EPC STORMWATER REVIEW COMMENTS  
IN ORANGE BOXES WITH BLACK TEXT

# OVERLOOK AT HOMESTEAD FILING NO. 1 PRE DEVELOPMENT GRADING AND EROSION CONTROL PLAN

PCD File EGP241

OVERLOOK AT HOMESTEAD FILING NO. 1
 EL PASO COUNTY, COLORADO
 PRE DEVELOPMENT GESC PLAN
CUT AND FILL PLAN

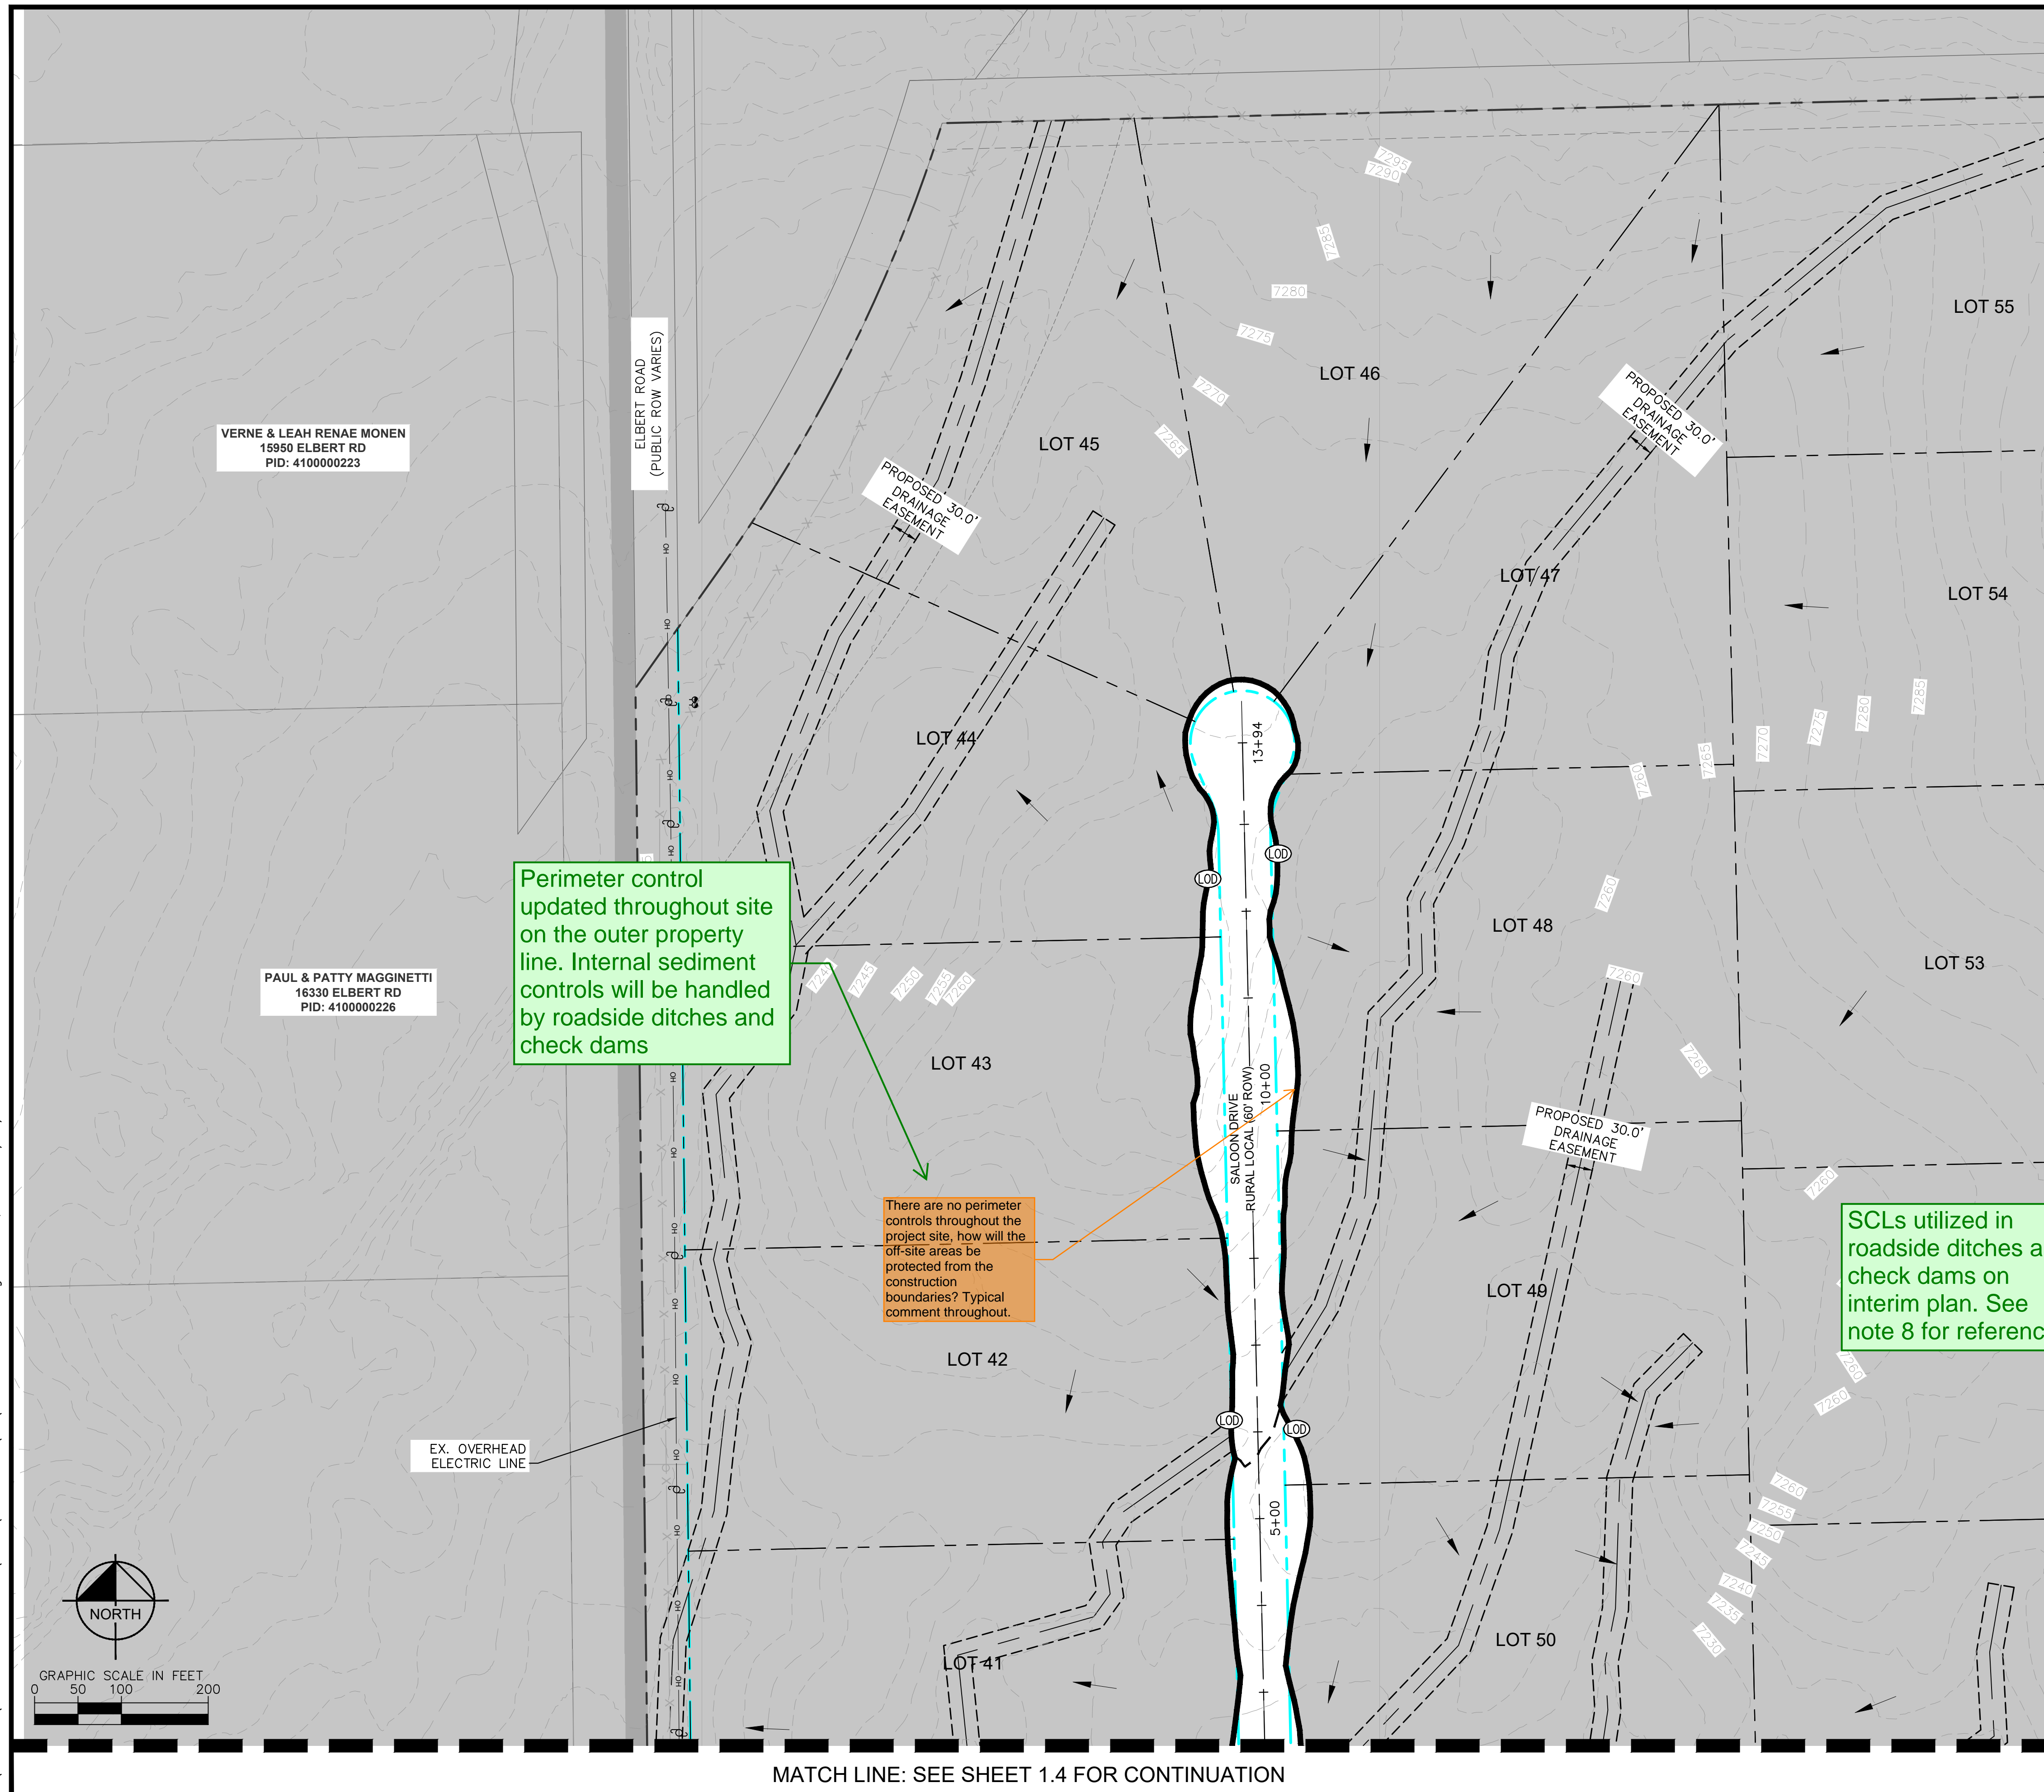
It appears that this area was not included in the FDR (basin OS-A2).
